Land at North West Bicester

Technical Note 2: Response to LLFA Drainage Comments

18th March 2022

| Status | | Status Date |
|---------------------------------|-------------|-------------|
| 1:5000 | 10663-DR-01 | D |

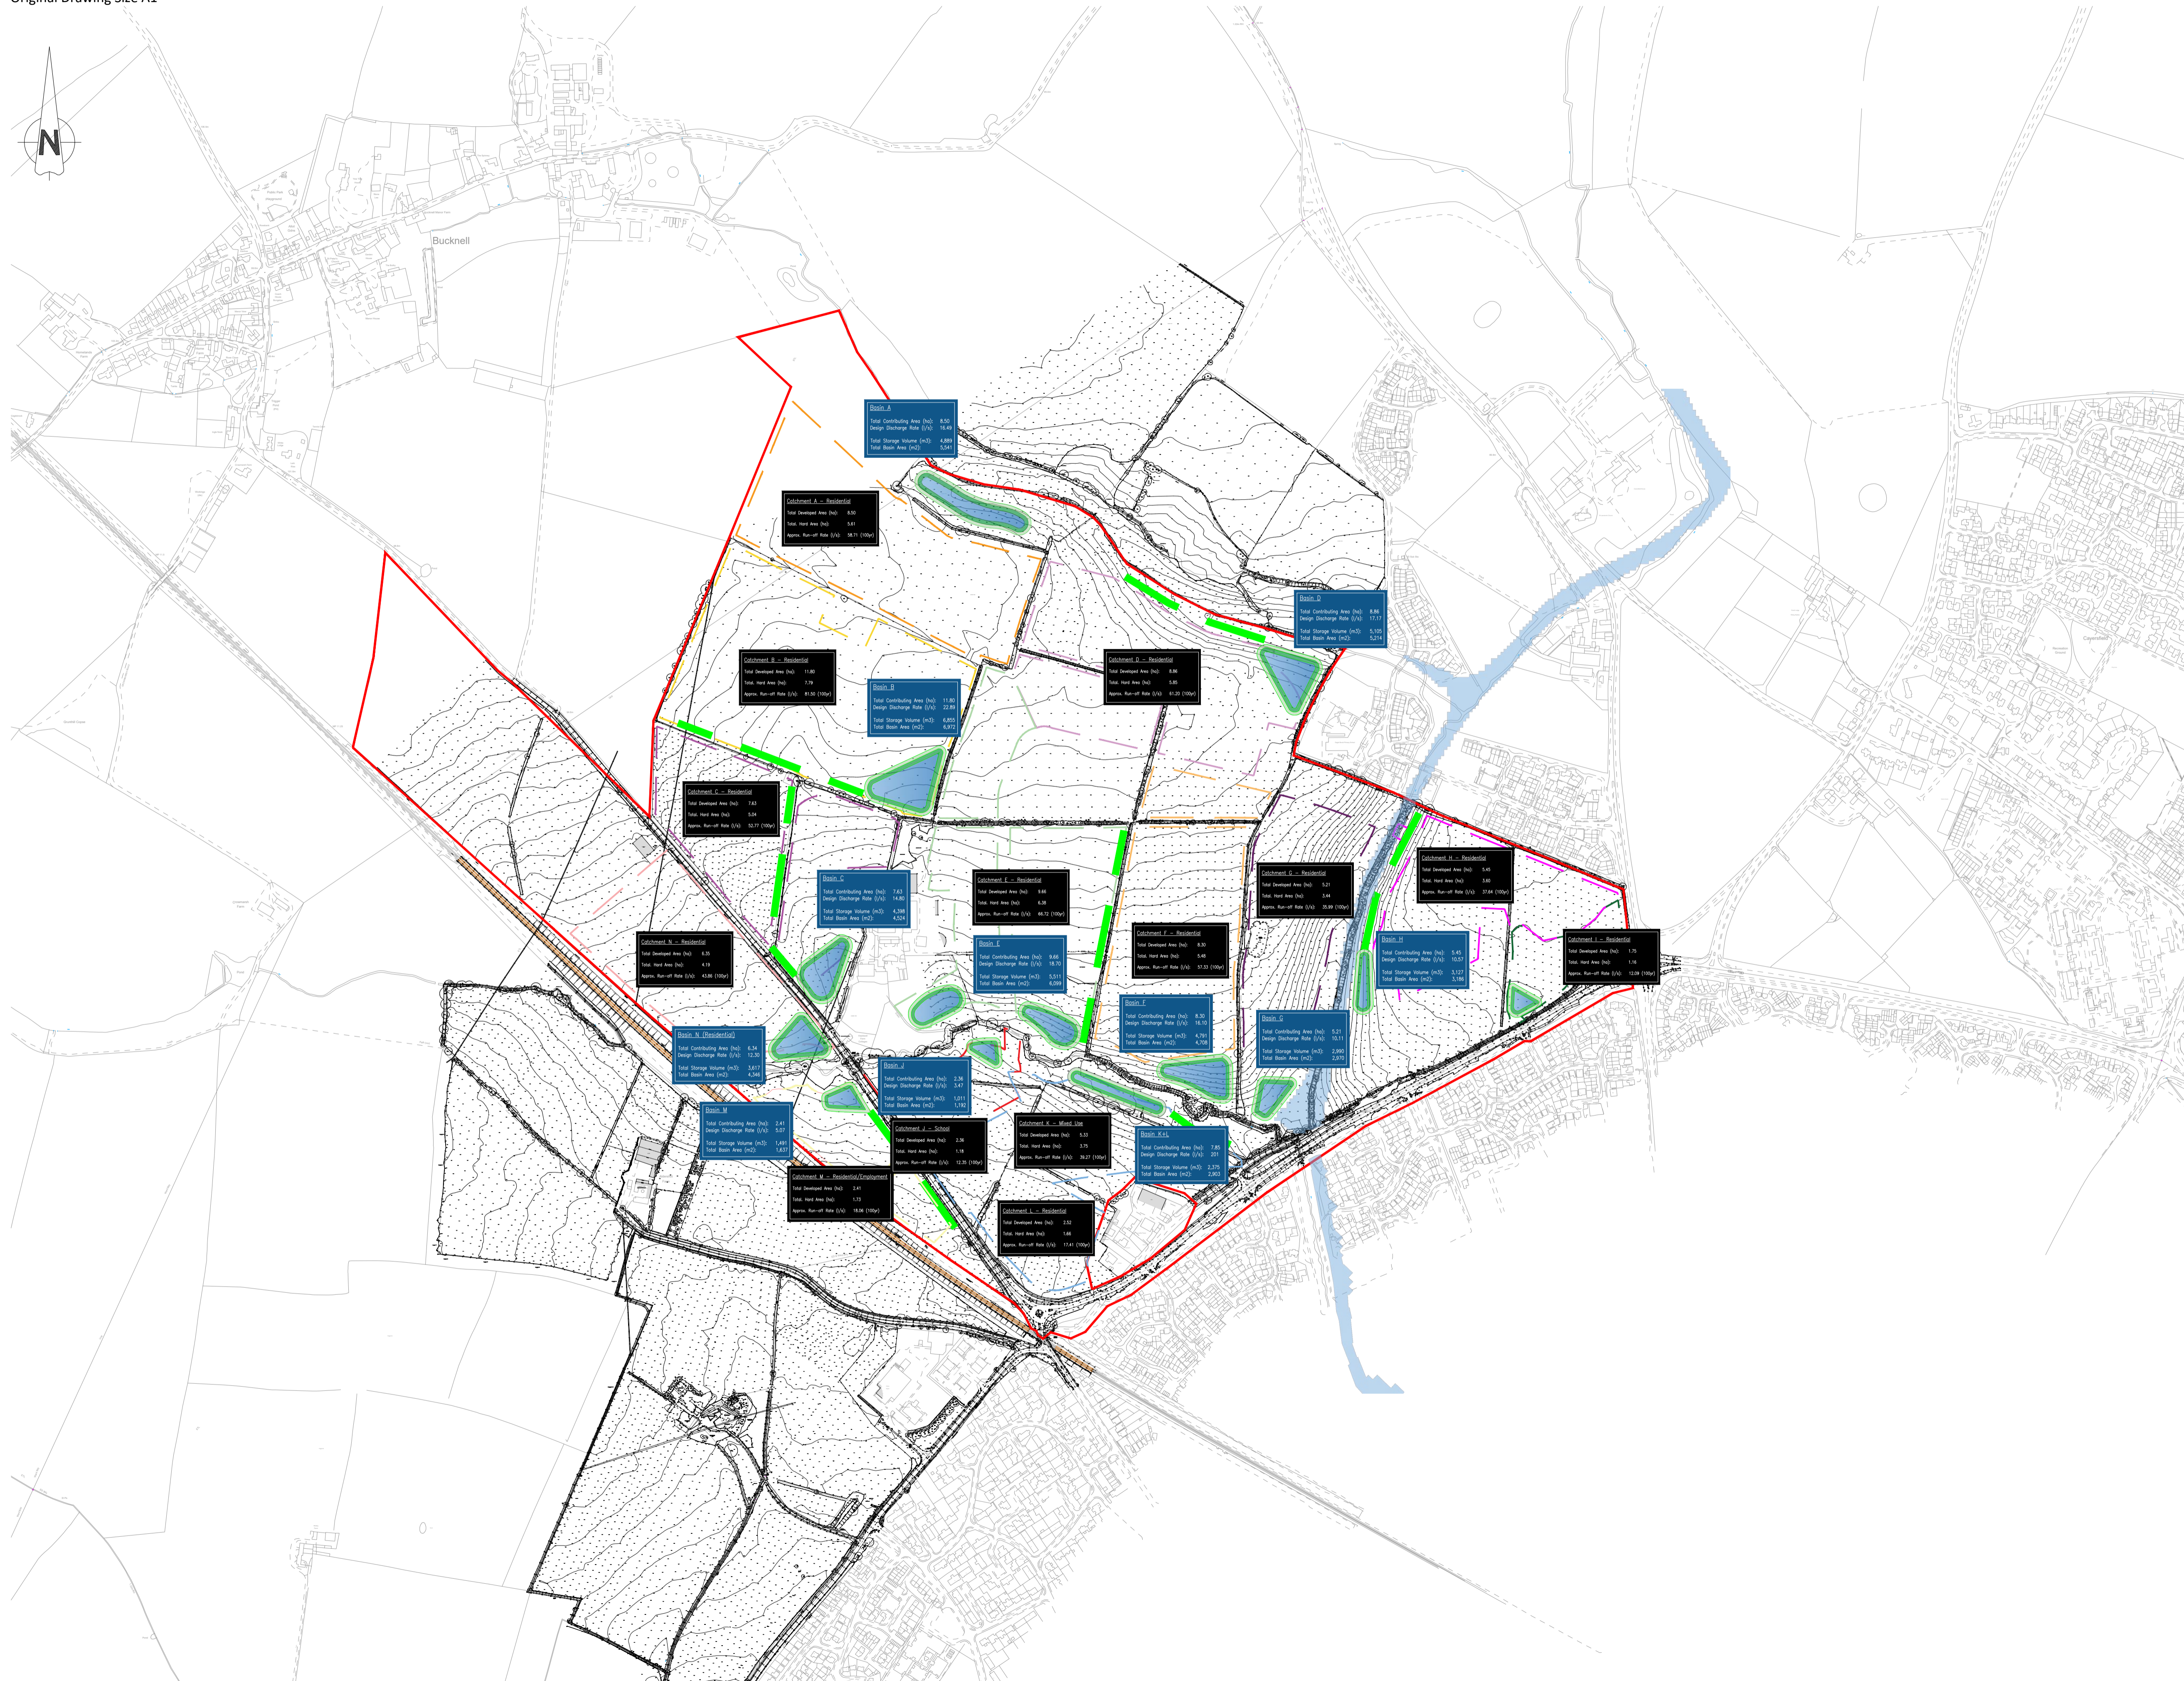
- 2.3 *The FRA explains the surface water drainage strategy however a surface water drainage drawing is required to demonstrate the surface water strategy. Proposed SuDS features and drainage infrastructure needs to be shown indicatively. Outfall locations to be shown, storage details of proposed SuDS features and infiltration rates if applicable.*

2.11 *Surface water exceedance flow plans required to demonstrate how the site is draining to ensure all surface water is being picked up by the proposed drainage infrastructure.*

- 2.4 A drainage strategy plan (10663-DR-01 D) has been provided as Appendix A of the Flood Risk Assessment (FRA). Drainage Strategy 10663-DR-01 E, have been appended to this note. This strategy plan includes clearer catchments areas and exceedance routes. The split between impermeable catchment area and impermeable area with urban creep has also been provided on the new plan.

- 2.9 Illustrated on drainage strategy plan (10663-DR-01 E), are the fourteen colour coded catchment areas across

2.12 Plan 10663-DR-01 E, illustrates a series of swales adjacent to the edge of the catchment parcels which will convey surface water from that parcel into the associated catchment detention basin.

2.13 Exceedance flow routes are also illustrated for the basins that are not directly adjacent to one of the onsite watercourses.
